Pagham Parish Council
Mr C C Braby
Village Hall
Pagham Road, Pagham
West Sussex
PO21 4NJ

Your Ref: OWQC280
Our Ref: P/28/13/
Please ask for:
Mrs J Chapman

Dwelling house and parking space (resubmission following P/33/12/)
14 Churchill Walk The Parade Pagham

proposed dwelling adj 14 Churchill Walk PAGHAM for Mr F Elliott	
plans, elevations & site layout	
PLAN NO	642/2
SCALES	1:100 1:50 1:500
DATE	03-13
DAVID J BROOKWELL 99 WESTMINSTER DRIVE BOGNOR REGIS PO21 3RG tel no 01243 264928

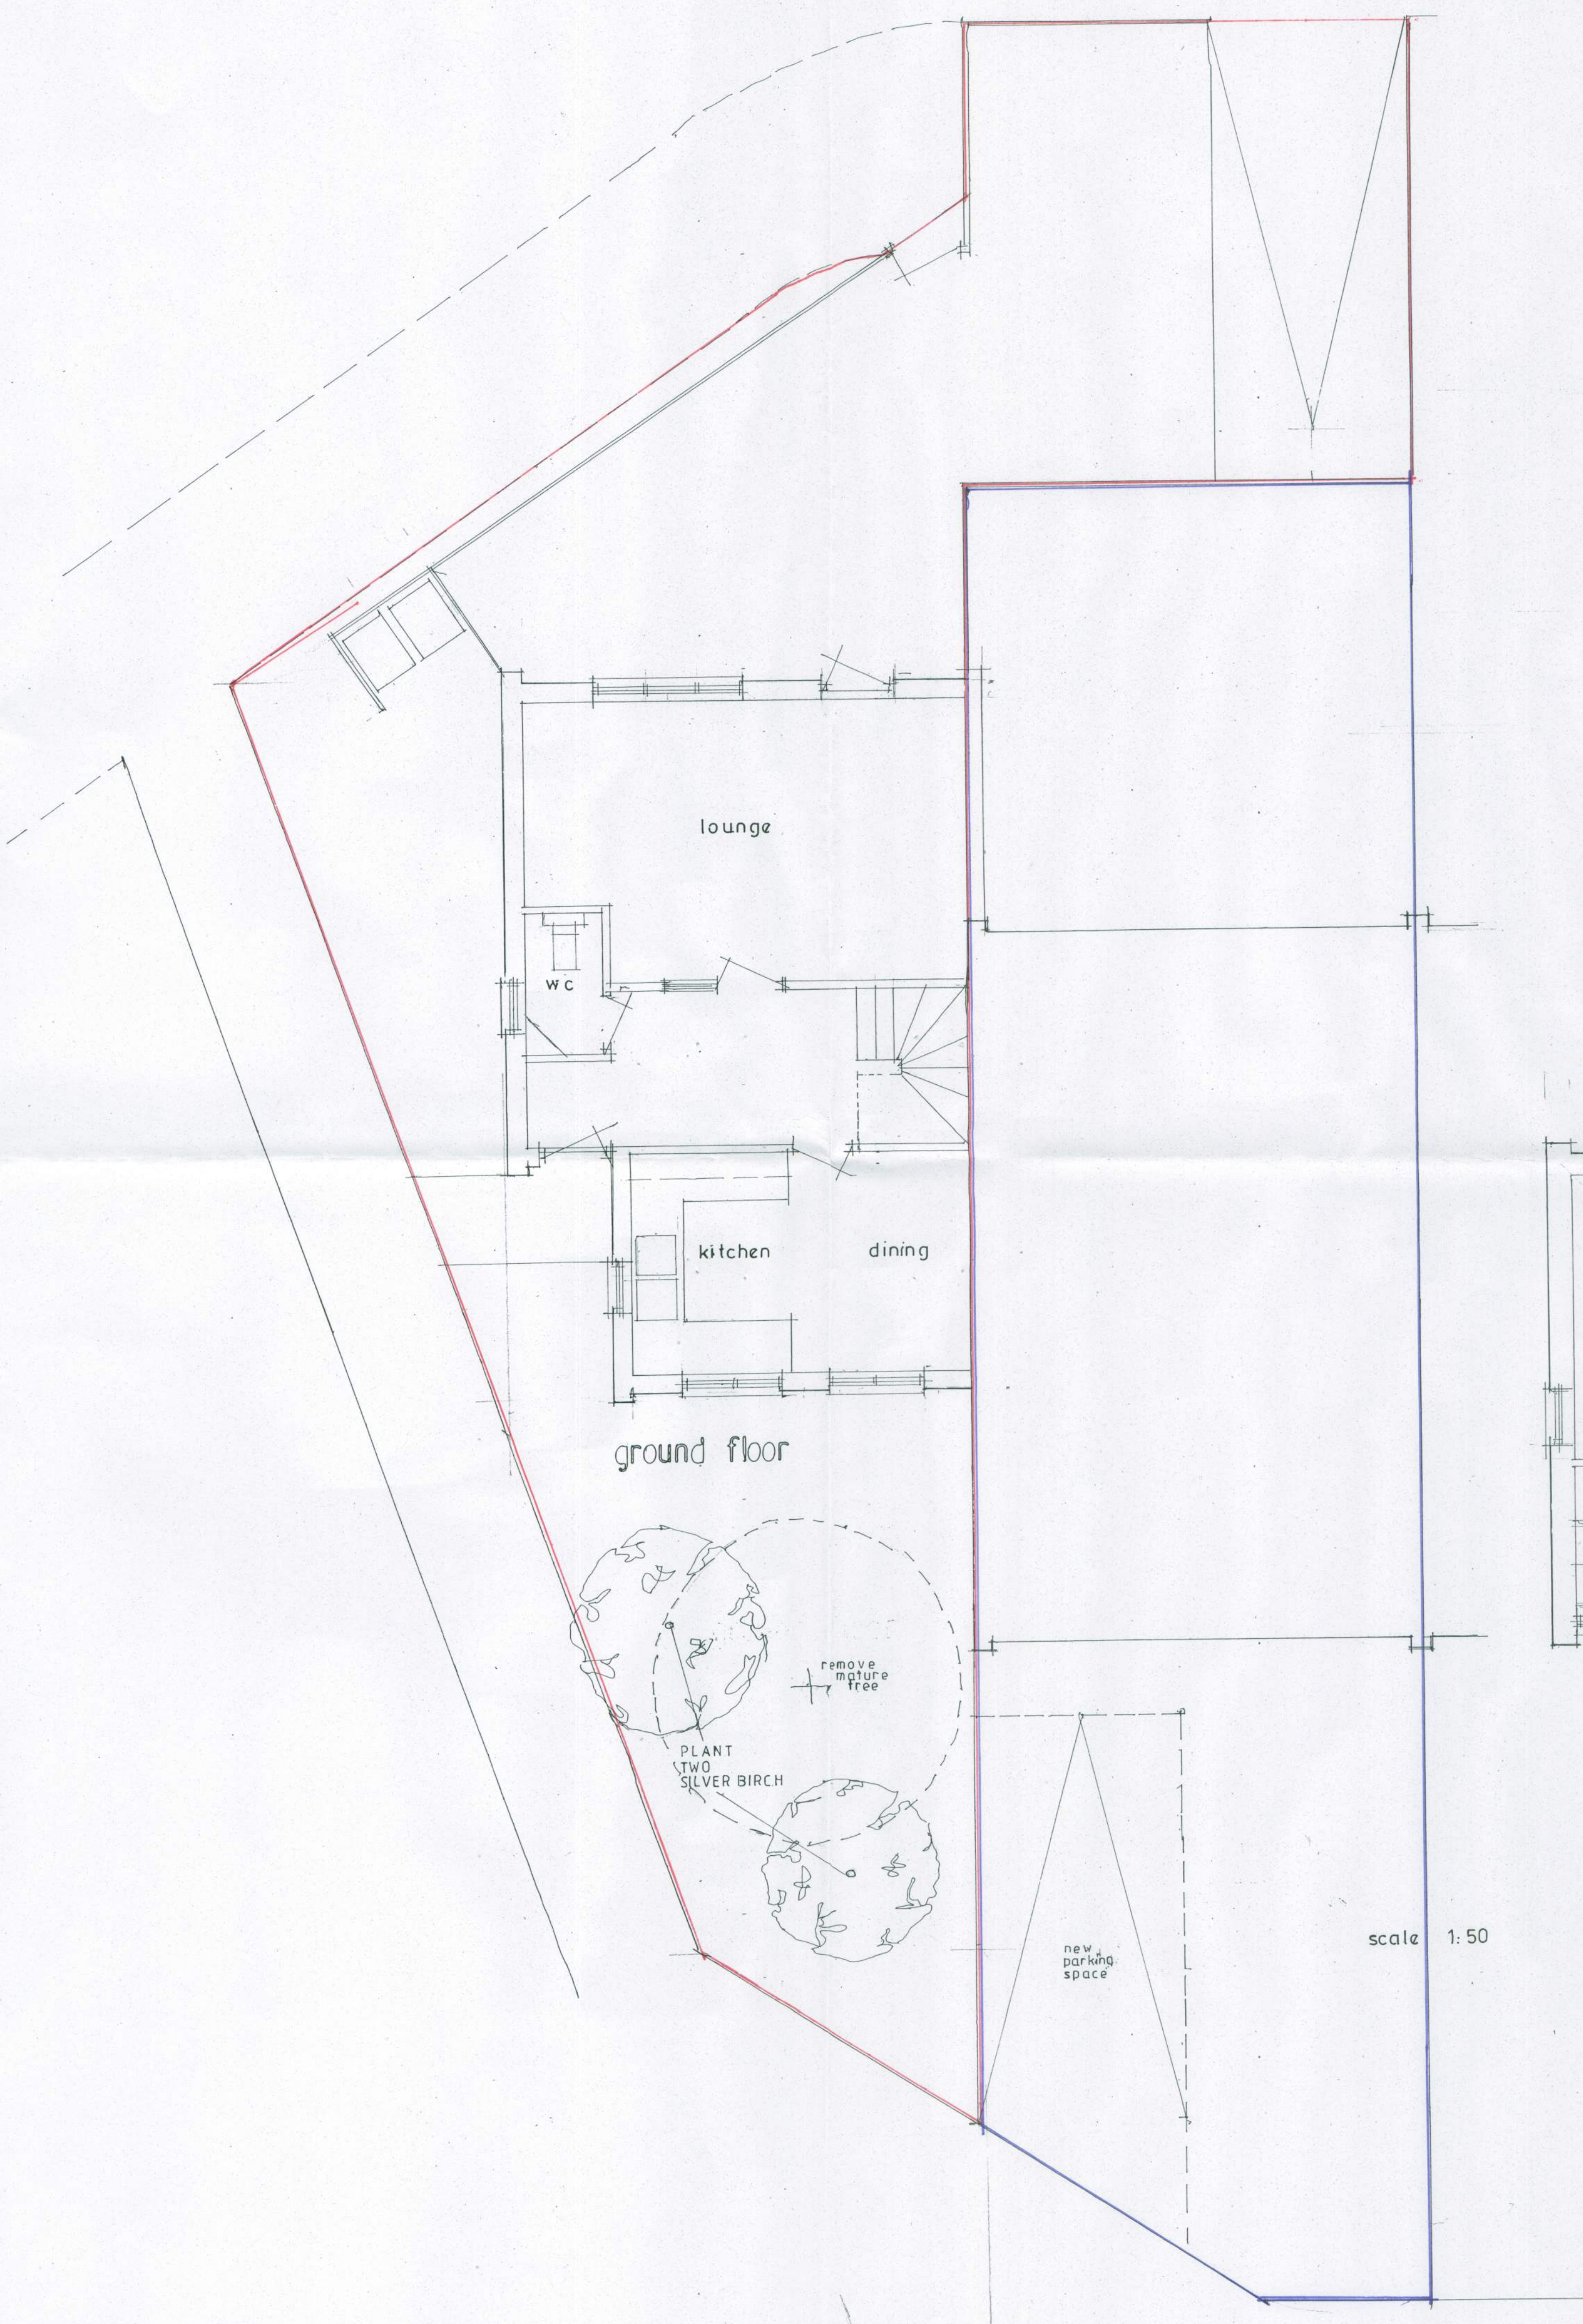
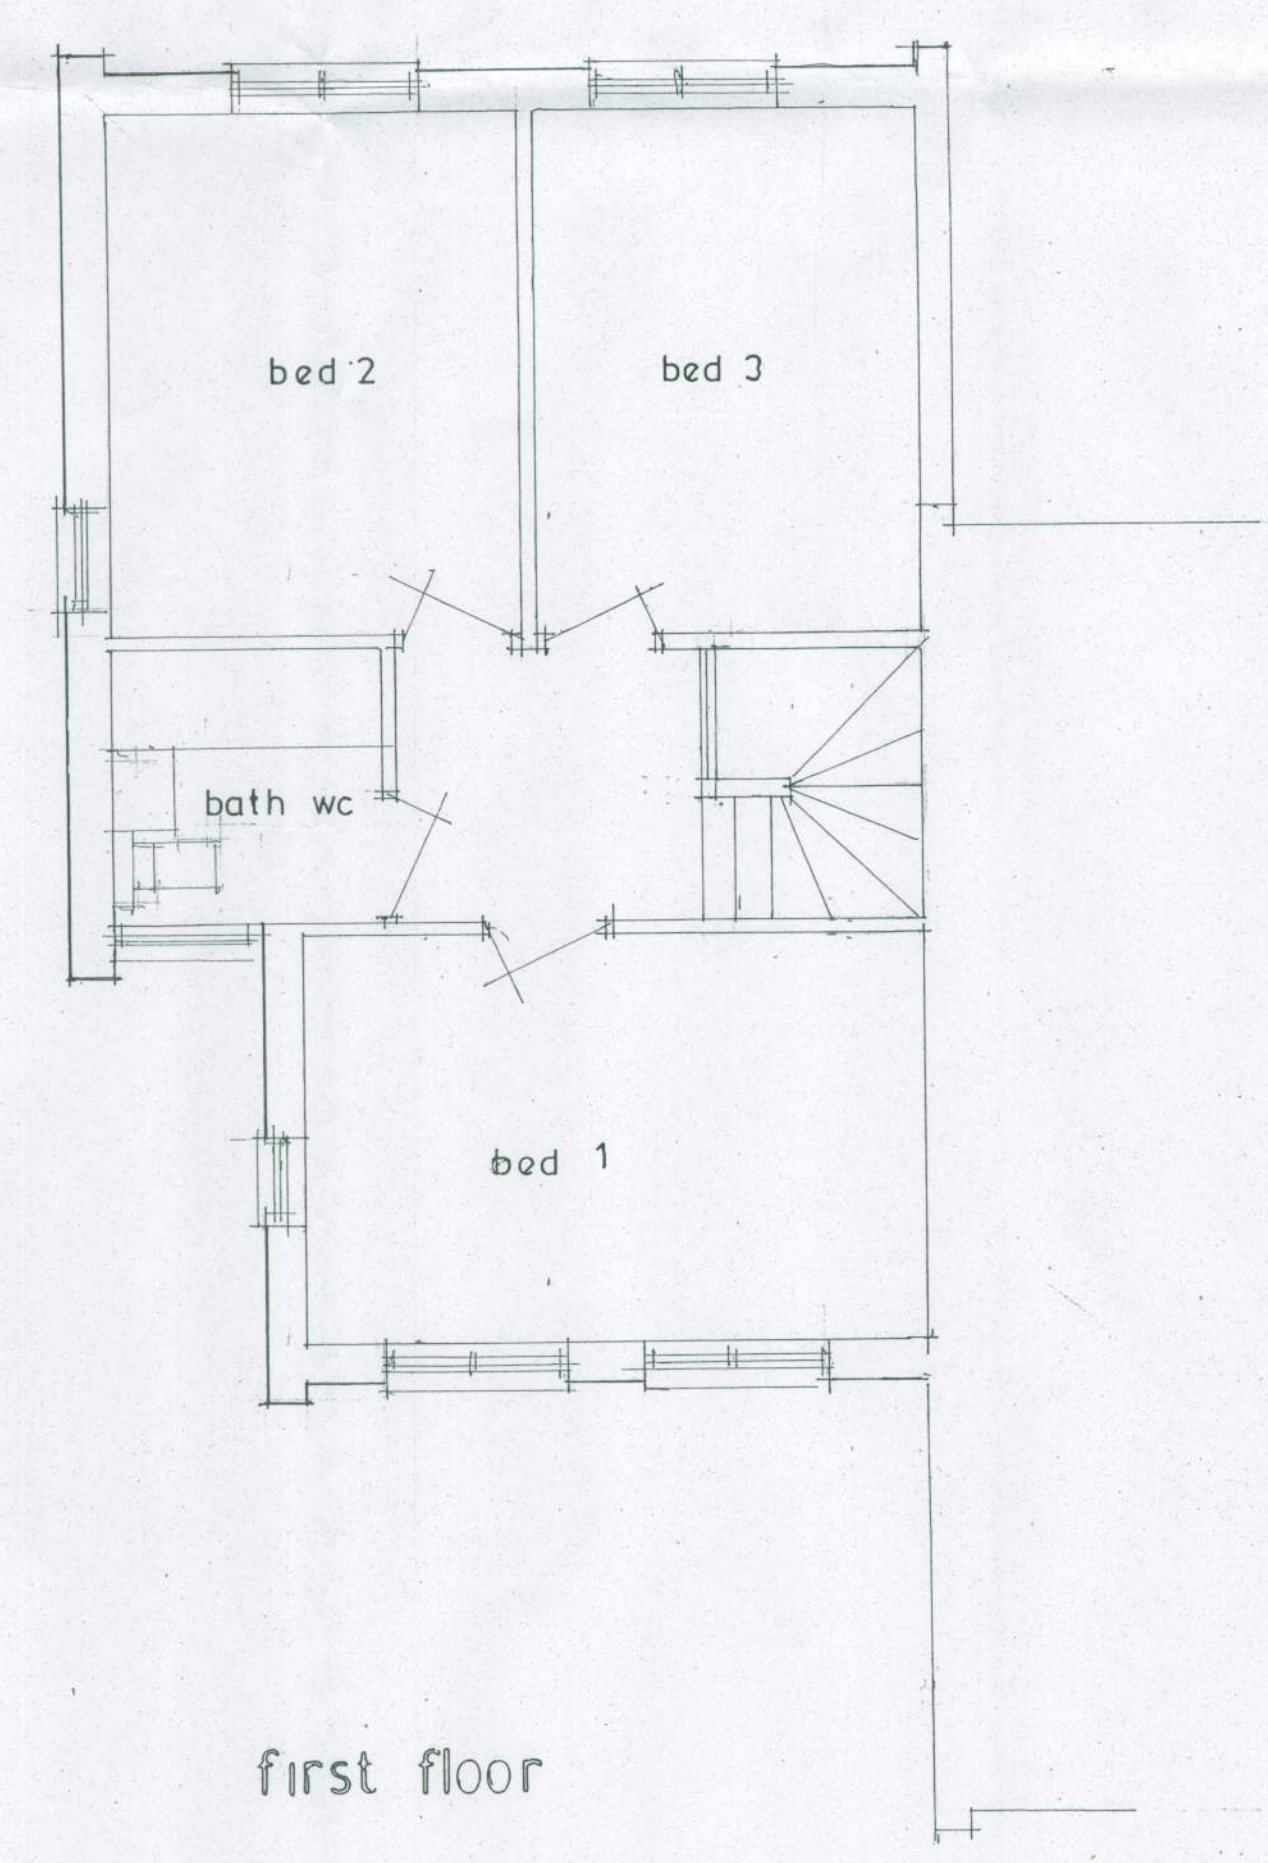
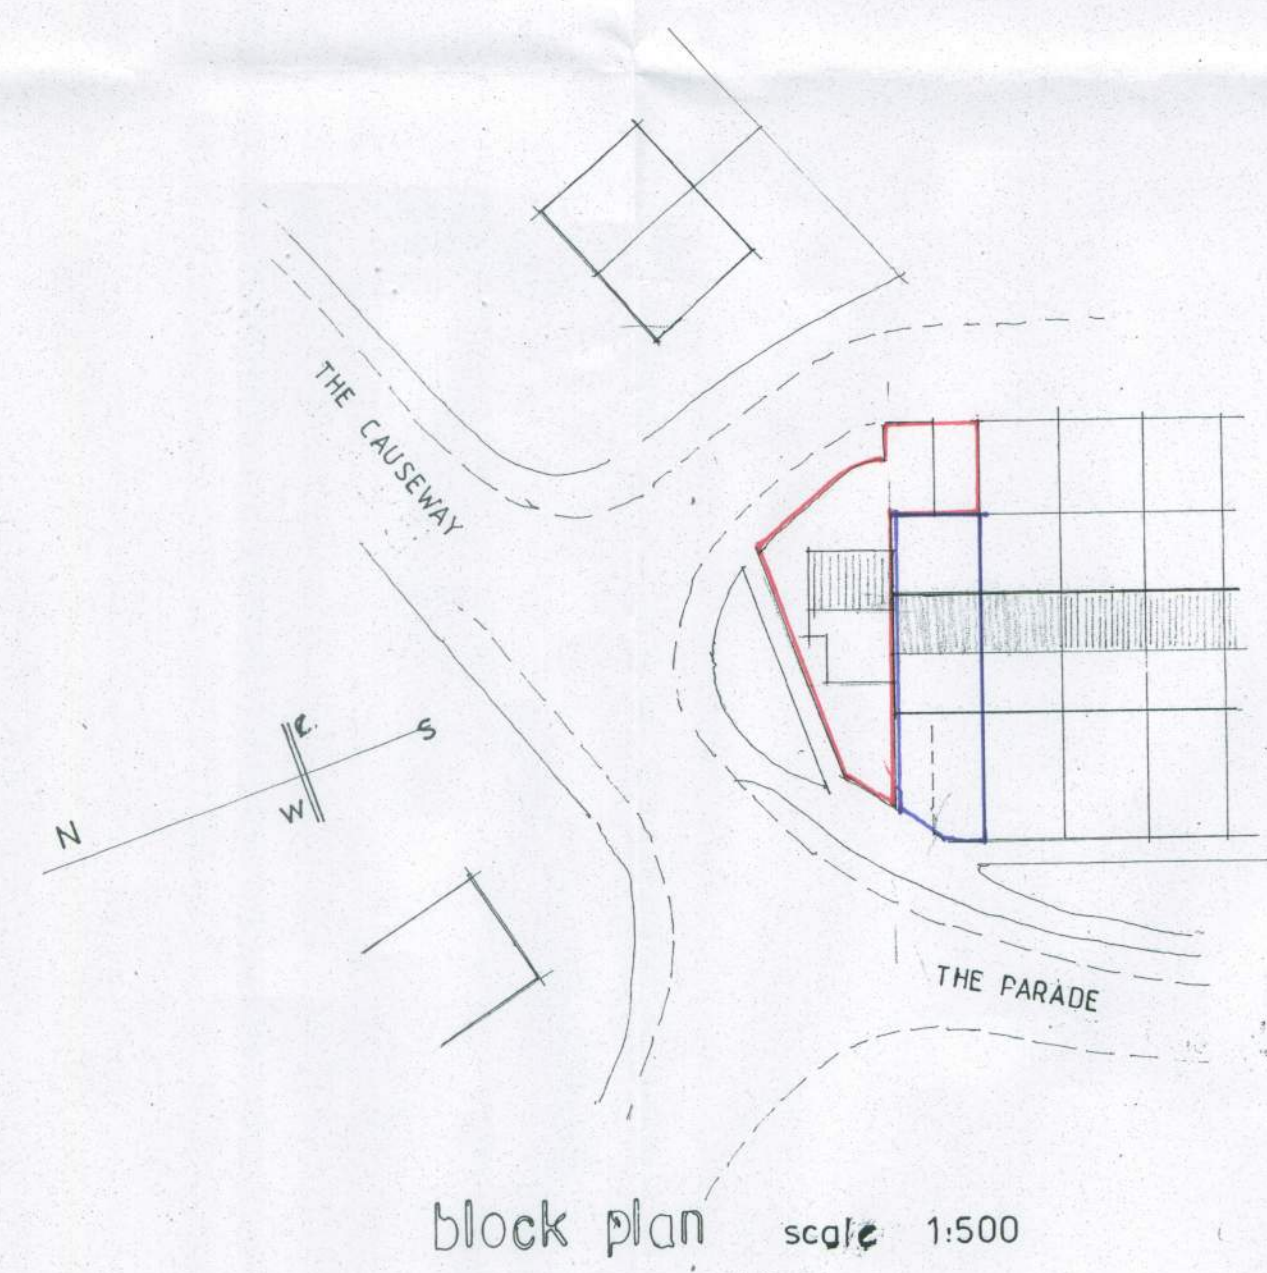
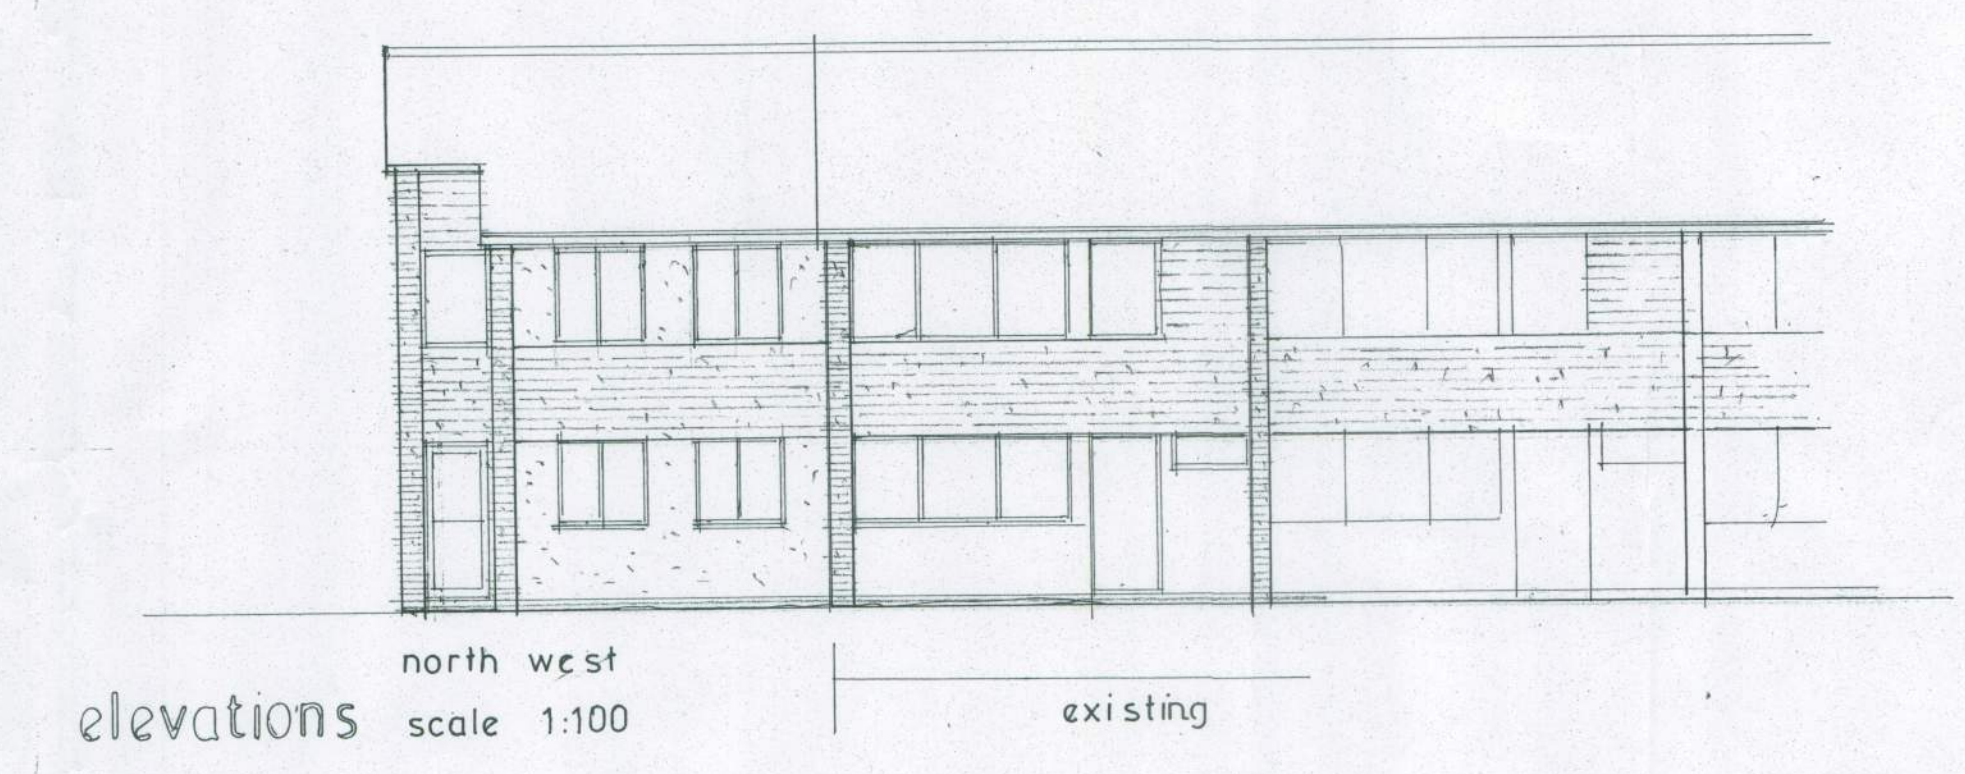
Members felt that the concerns they expressed in respect of previous submissions for a new dwelling on this site were still valid. This was an enclosure and hence reduction of the previously open aspect which is a feature of the 1960 s estate.

It was felt to be an inappropriate and ill-matched addition to a standardised and regular design of terrace. It had previously been the subject of flood risk assessment, having regard to the 2008 Coastal Defence Strategy, associated EA flood maps and subsequent SFRA indicative sea incursion.

NPPF advocates sustainable development, having regard to climate change/tidal rise predictions and the provisions of PPS25, new development adjacent to an erosion zone might thus be deemed non-compliant.

Page 7 (2) Kings Beach Estate Churchill Walk. Retain open plan aspect. Preserve existing green space and amenity trees within development. . New buildings not to vary significantly in height or bulk un-neighbourly, cramped, visually intrusive ill-conceived linkage
